Permit Number: **BCOM2604-0011**

Description: **Afreya's Playground**

### LIST OF REVIEWS

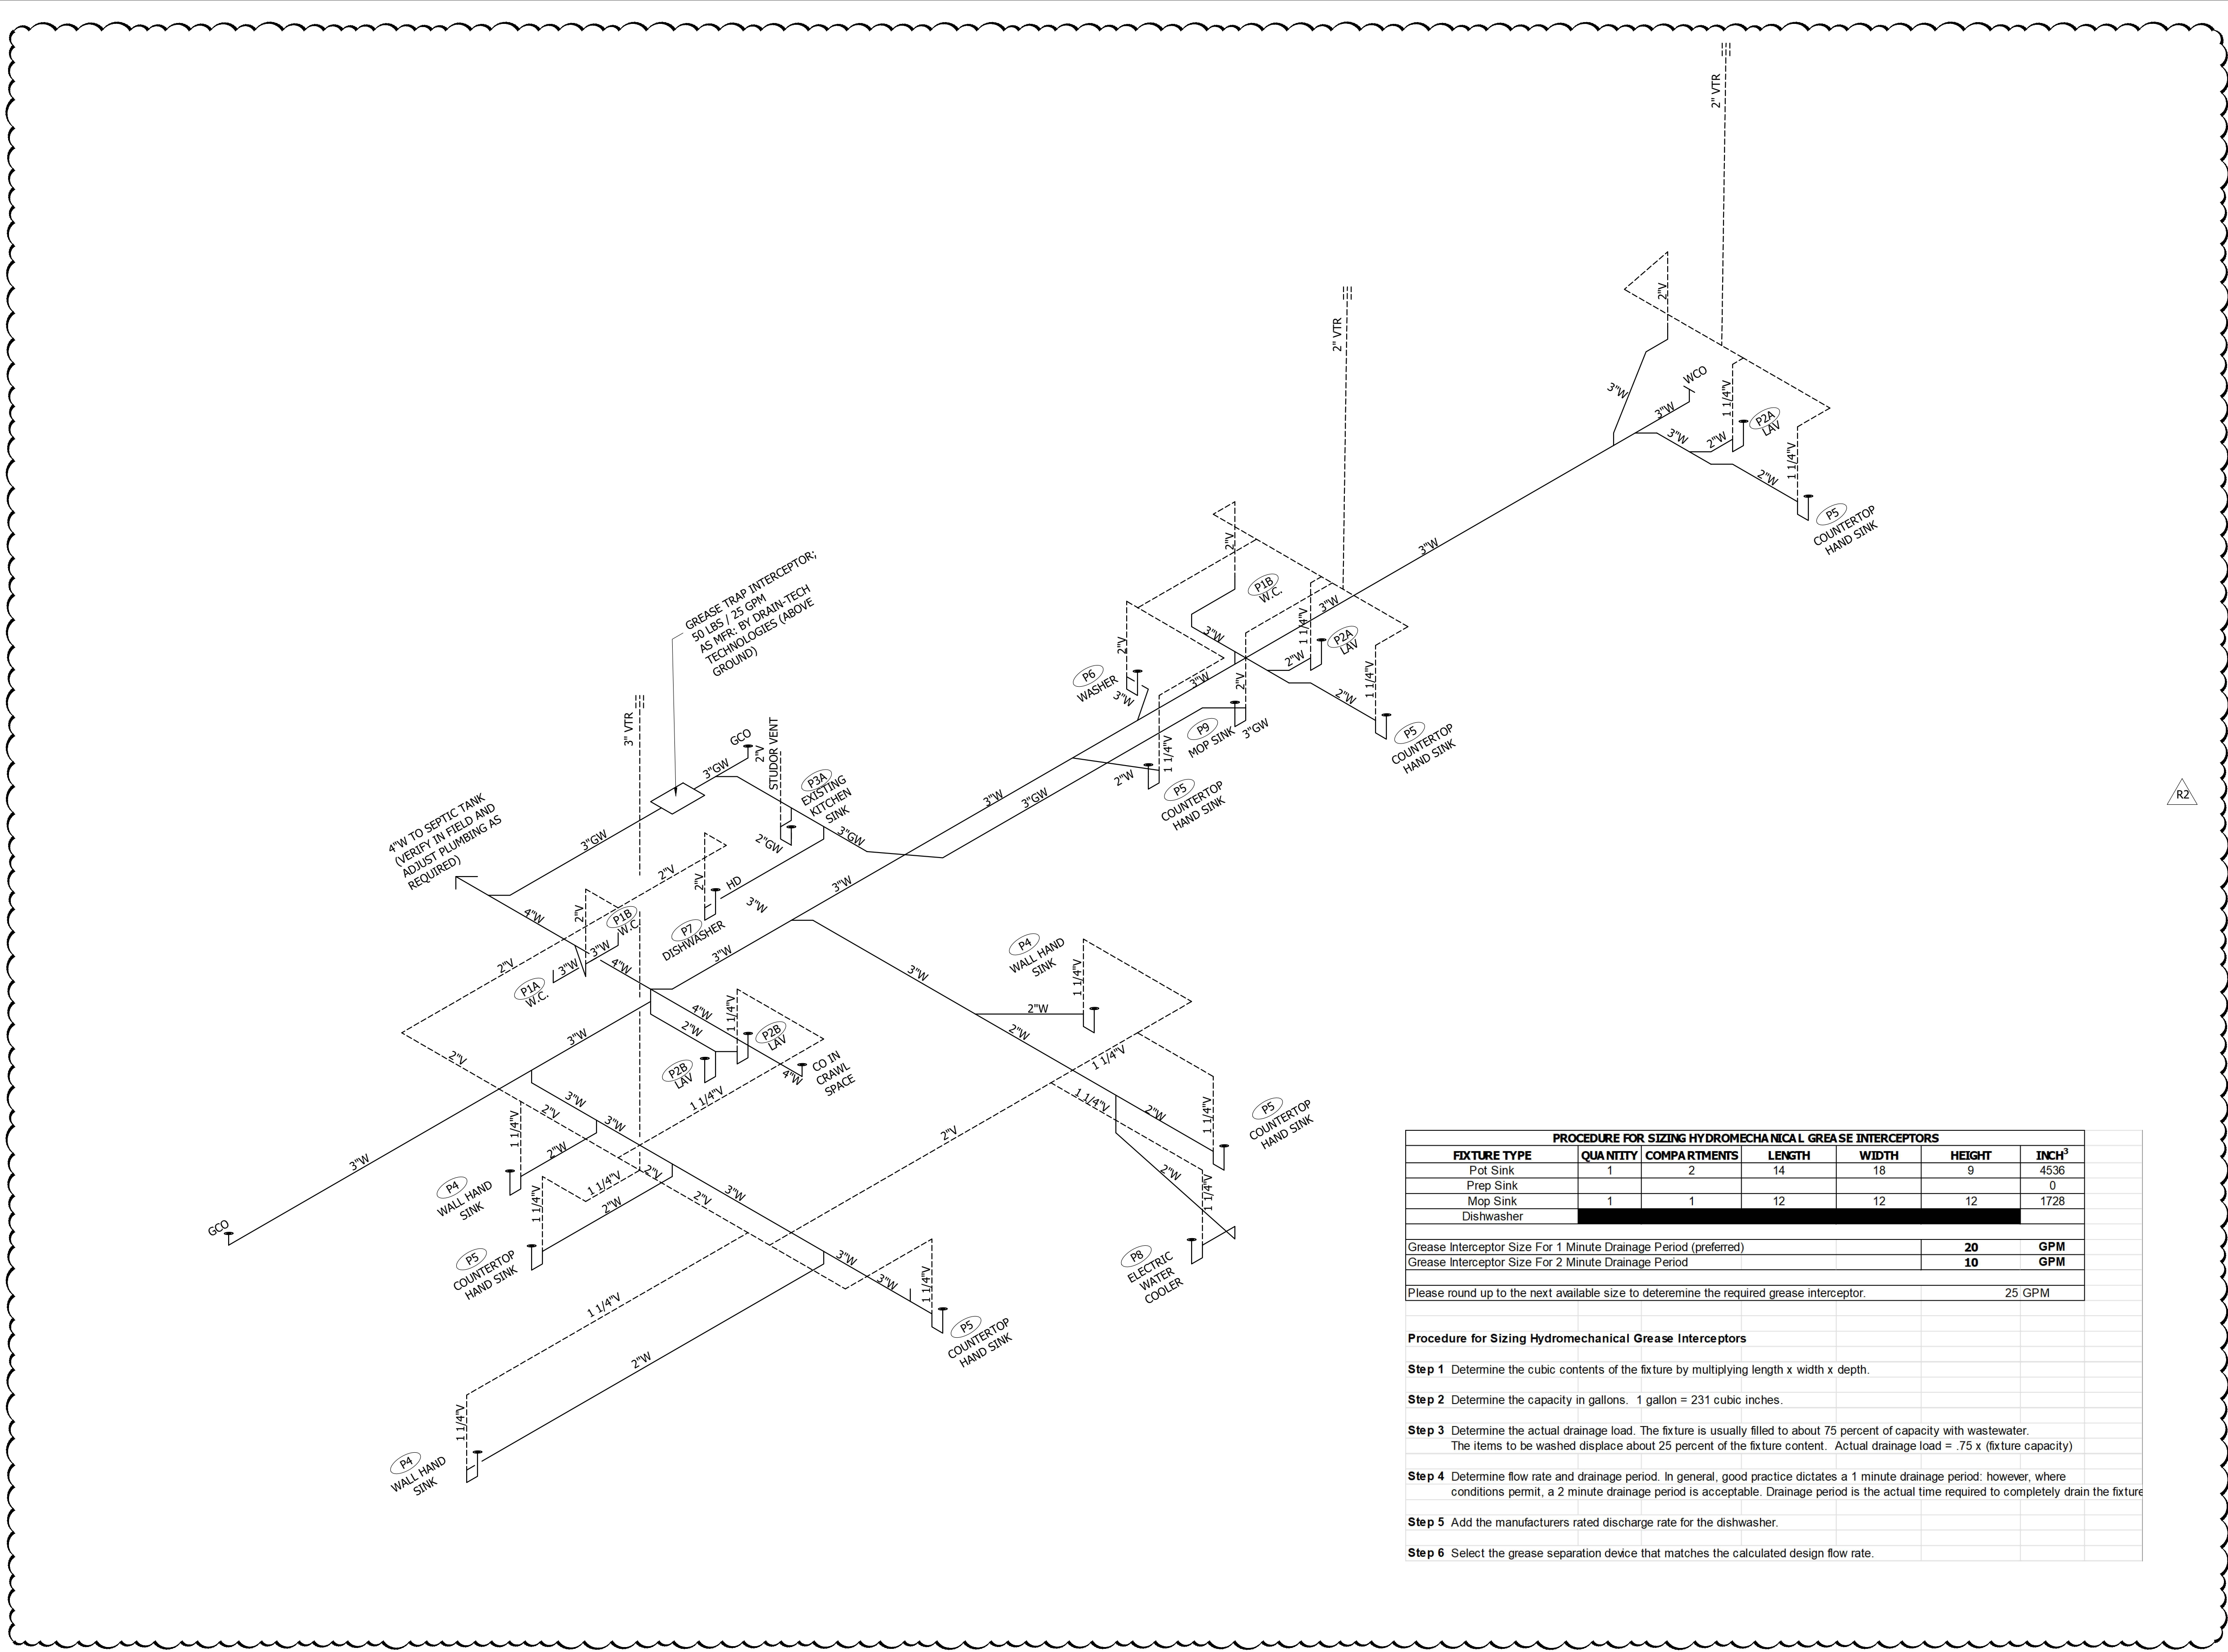
5/12/2026	5/27/2026	5/27/2026	HEALTH AND SANITATION	Cynthia Pierce	DISAPPROVED	more info needed
<p>Notes:</p> <p>Please confirm is a grease trap is necessary--this building is on septic.</p> <p>Grease trap is required. CP</p> <p>Plans need to be updated with items discussed on phone call with Ms. Afreya Munroe 5/27/26. Specifically, the nature of the openings to the kitchen area and the use of the adjoining room currently labeled staff lounge. Also, hot water heating and supply and kitchen lighting.</p>						
Review Group: AUTO						
4/21/2026	5/27/2026		COMMERCIAL INTAKE	CP Bucket	DISAPPROVED	SITE2603-0001
Notes:						
4/21/2026	5/5/2026	5/5/2026	COMMERCIAL BUILDING REVIEW	Brad Sutton	UNDER REVIEW	
Notes:						
Awaiting response to EH requirement for plumbing changes. I will need to review the change.						
4/21/2026	4/28/2026	5/5/2026	FIRE MARSHAL	Leslie Jackson	DISAPPROVED	see notes
Notes:

**FIRE SAFETY LEGEND**

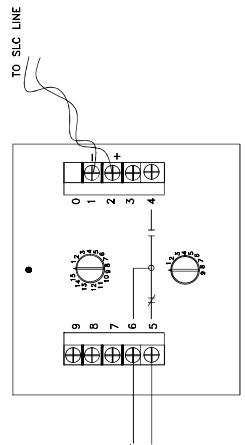
SENT DATE	RETURNED DATE	DUE DATE	TYPE	CONTACT	STATUS	REMARKS
Review Group: 1ST PLAN REVIEW						
4/21/2026	4/27/2026	5/5/2026	HEALTH AND SANITATION	Cynthia Pierce	DISAPPROVED	See attached letter
Notes: Per Parm, "there is no food preparation on site. The food menu includes pre-cooked frozen items like chicken nuggets etc." See attached letter						
4/22/2026	4/22/2026	4/29/2026	ENVIRONMENTAL	Maggie Watkins	APPROVED	
Notes:						
Review Group: 2ND PLAN REVIEW						
5/12/2026		5/27/2026	COMMERCIAL BUILDING REVIEW	Building Bucket		
Notes:						
5/12/2026	5/27/2026	5/27/2026	FIRE MARSHAL	Roger Sullivan	DISAPPROVED	
Notes: Refer to notes from TRC meeting on 12/4/25 below: - There must be a fire hydrant within 400 feet of the building as measured by an approved road route to the farthest point of the building. - The access road must be 20 feet in clear width, 13" 6" in clear height, an all weather surface capable of supporting 75,000 pounds. - If the access road exceeds 150 feet in length and deadends, then there must be an approved fire apparatus turnaround. - The access road must extend to within 150 feet of all portions of the building. Also fire alarm plans are incomplete missing battery calculations, spec & data sheets on all devices, appliances & fire alarm panel to be installed, pull stations are not noted at all exit doors and layout of interior of building is faded on the plans.
